New roof with first floor accomodation, dormer to side elevation, porch to side elevation
& single storey rear extension (revision to previously approved BR/305/17/HH).

30 Mansfield Road Bognor Regis

Thank you for your internet representation made on 12th April 2018 which has been recorded
as '**an objection**' with the comments as follows:

PROPOSED ELEVATIONS

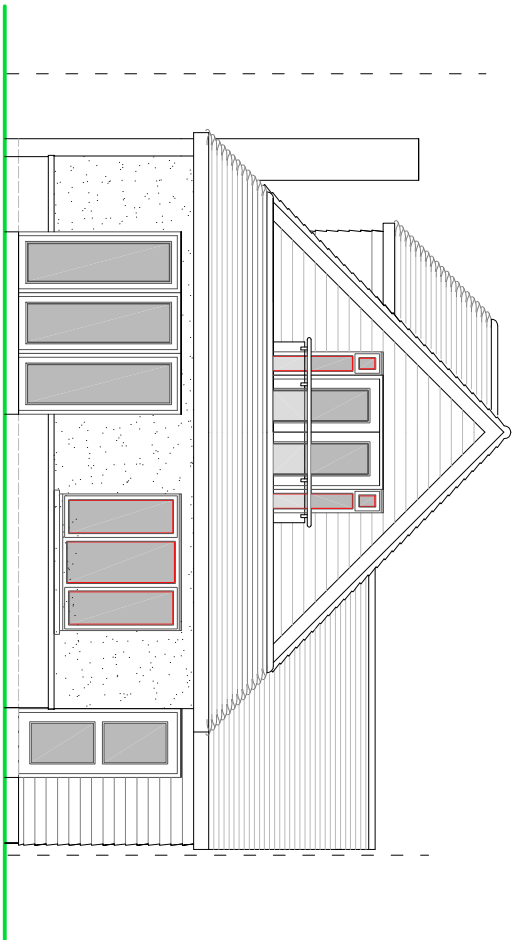
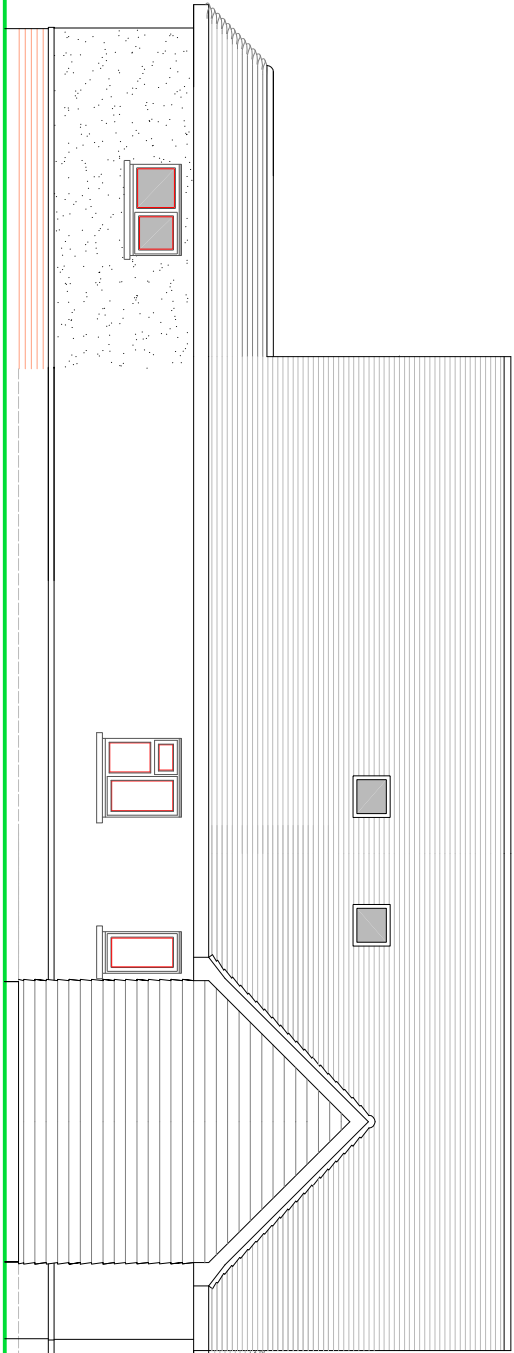
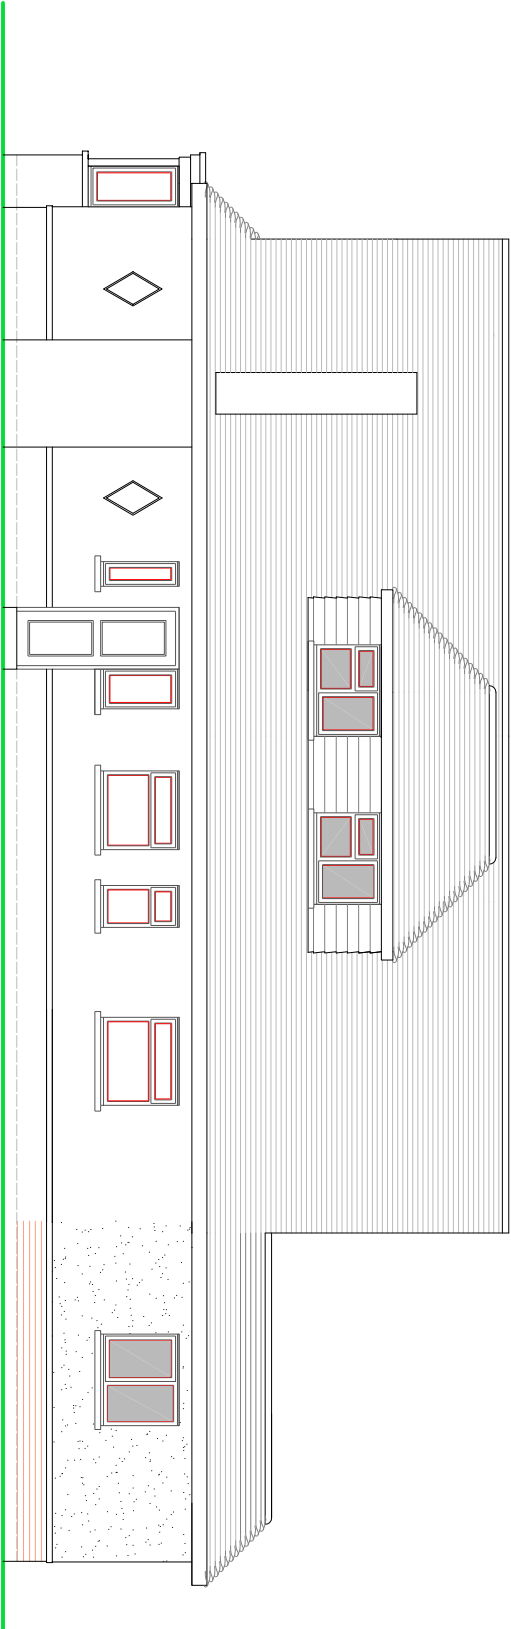
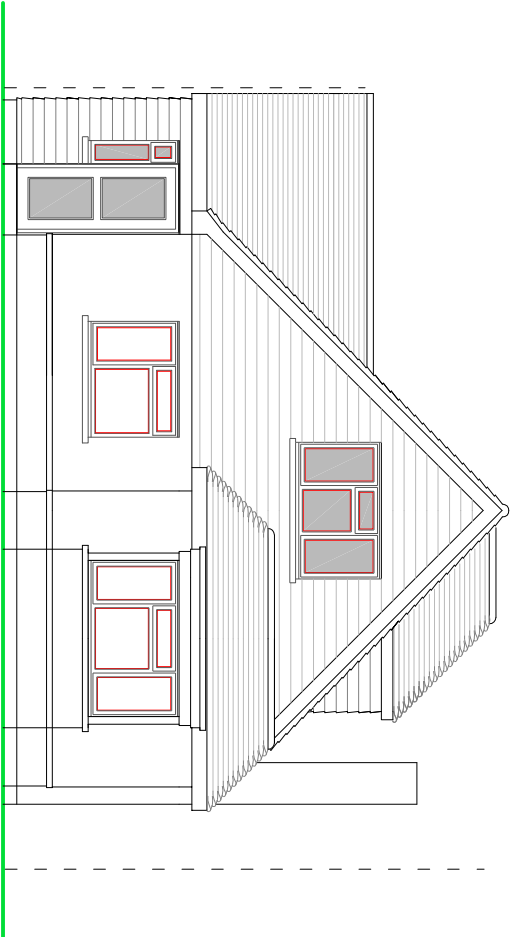
*Under the old application it was conditioned that the Windows in the South facing former
to be obscured glass and fixed shut if lower than 1.7 metres from the floor level. Please
ensure that this condition is applied to this new application.*
